Centennial Airly Pty Limited,
Airly Mine,
319 Glen Davis Road,
Capertee,
NSW, 2846

**Mine Subsidence Consulting Engineering Peer Review of Report on
Subsidence Predictions and Impact Assessments for Airly Mine**

We are pleased to provide the following independent peer review of a report titled "*Subsidence Predictions and Impact Assessments for Airly Mine*" (Subsidence Prediction Report) that was prepared by Golder Associates Pty Ltd (Golders) in 2014 and is referenced as Report 127621105-003-R with 94 pages. This report was prepared to supplement a report, titled "*Environmental Impact Statement – Airly Mine Extension Project*" (EIS Report), that was prepared by Golders in September 2014 and is referenced as Report 137623024_061_R_Rev2, Ch I-12, with 545 pages. This EIS Report was prepared in support an application to extend the operating life of the Airly Mine (The Project) by continuing coal extraction to the east of the currently approved areas.

Engineer:	M. MacKinnon	Client:	Airly Mine		
Drawn:	B. Richardson	Title:	Typical Sections Showing Proposed Mining Zones		
Date:	04.11.13				
GOLDER ASSOCIATES PTY. LTD. www.golder.com		Ref:	127621105-003	Revision No:	N/A
		Scale:	NTS	Figure No:	32

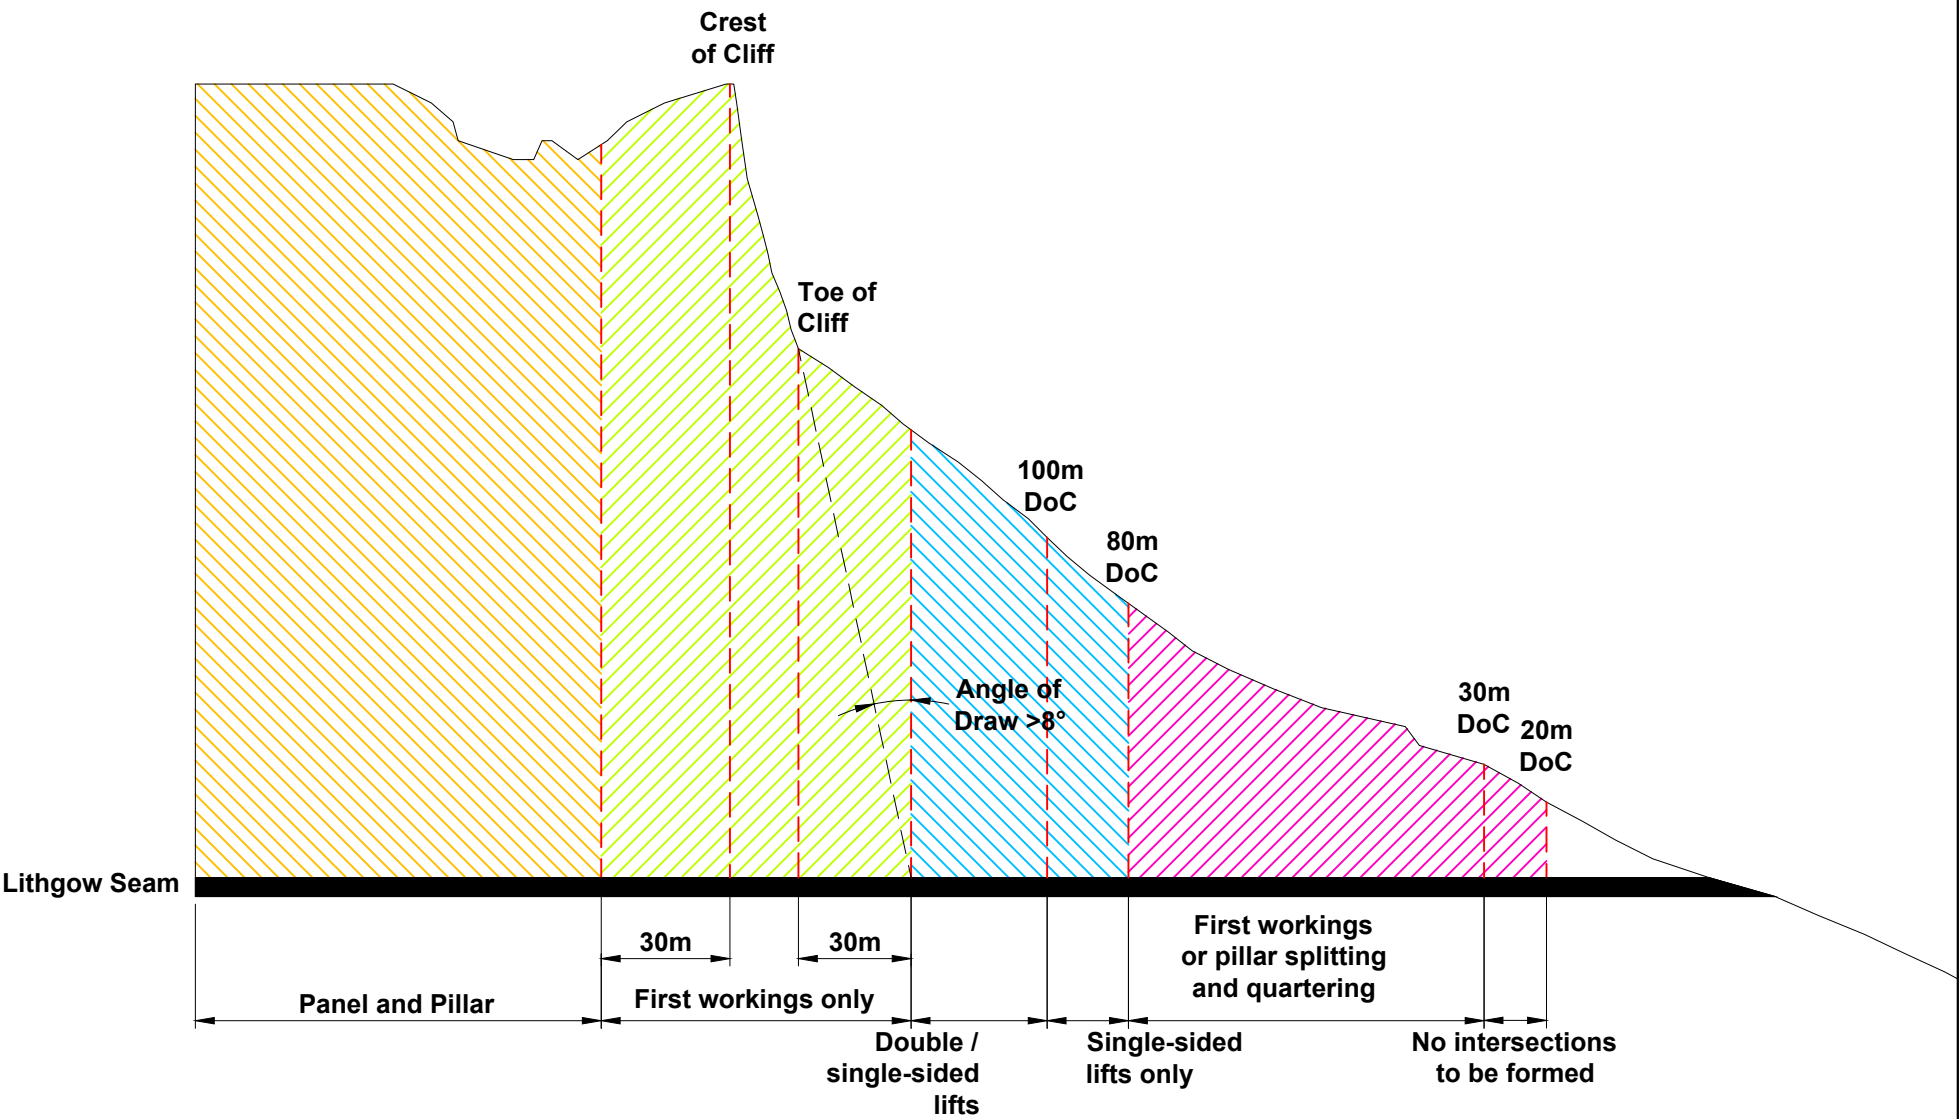
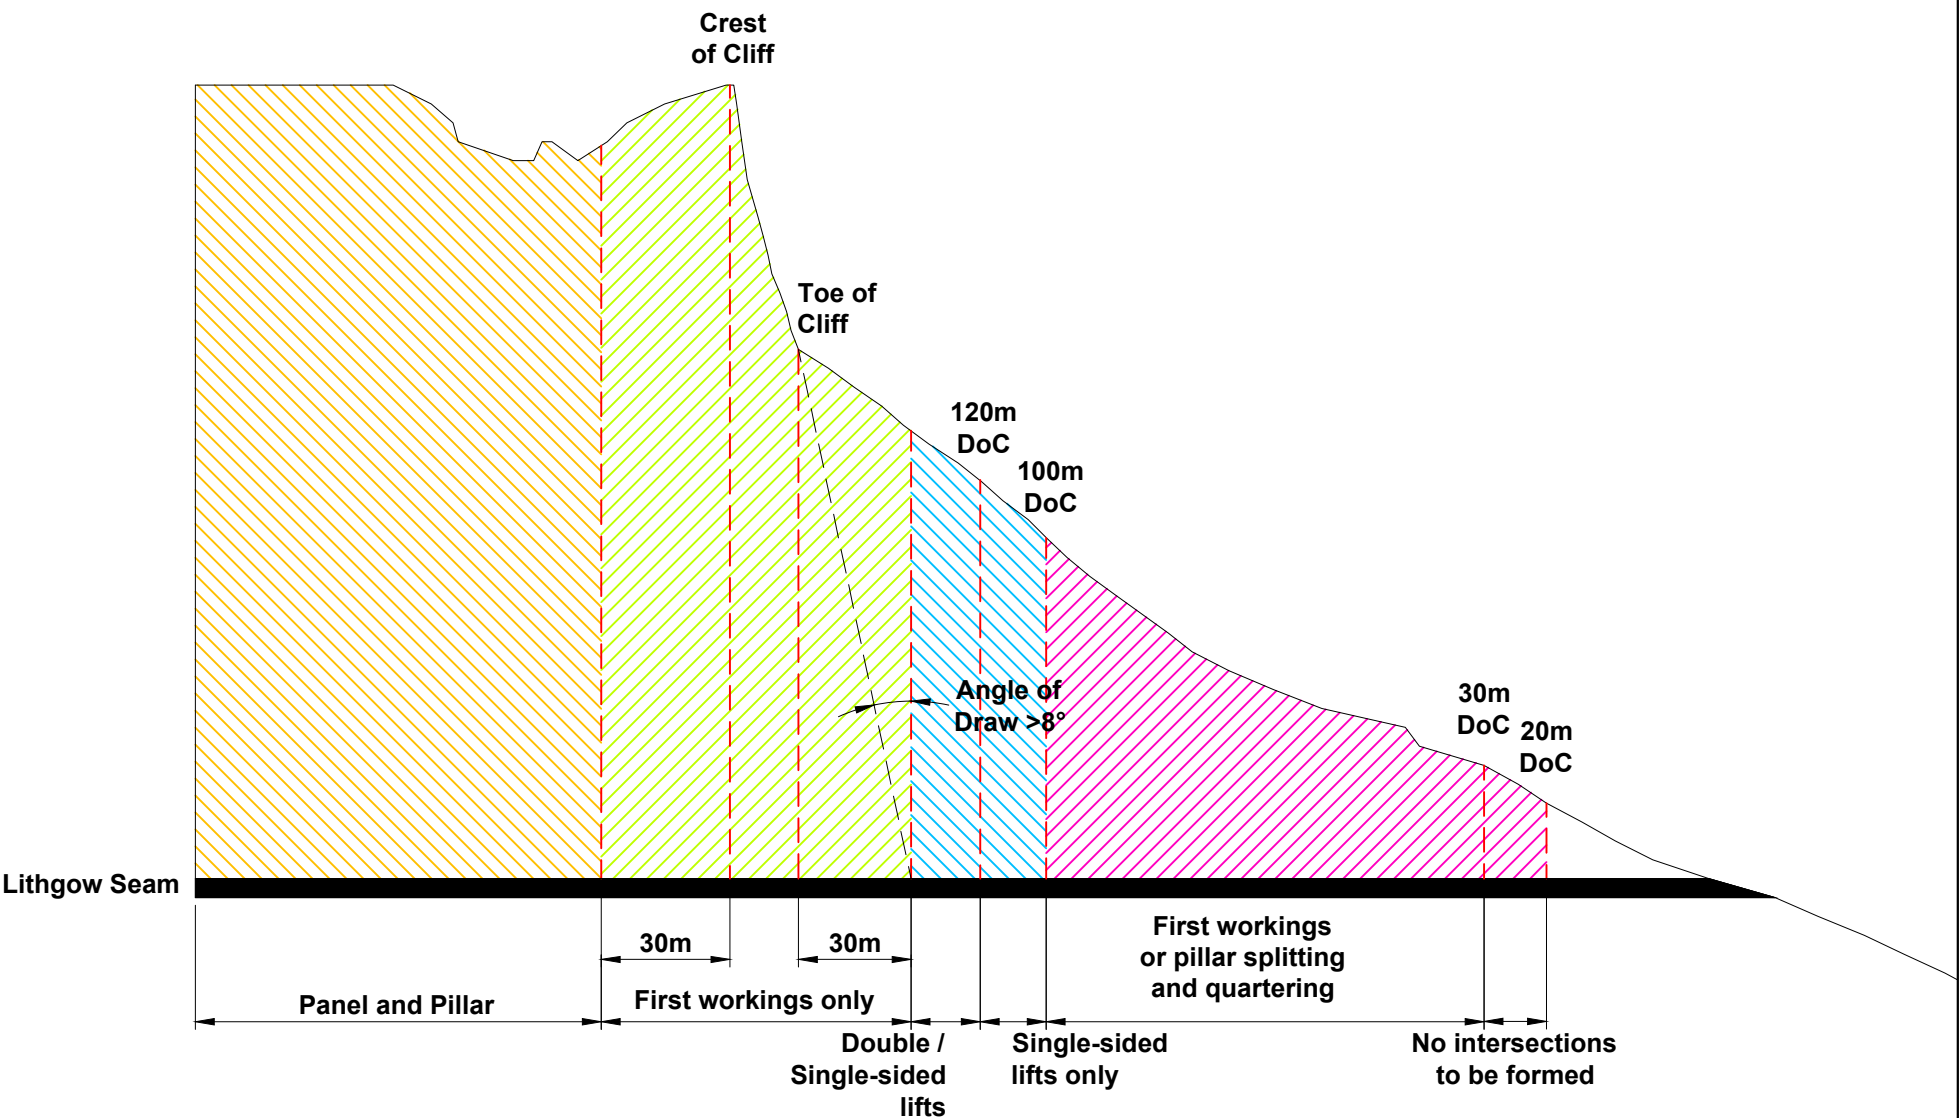
The most restrictive forms of mining are proposed in the vicinity of the Cliff Line Zones, where only bord and pillar first workings are proposed with no subsequent pillar extraction, splitting or quartering. (See copy of following cross section AA from the Subsidence Prediction Report.

(ii) Typical Section Showing Mining Zones with Potential Flooding
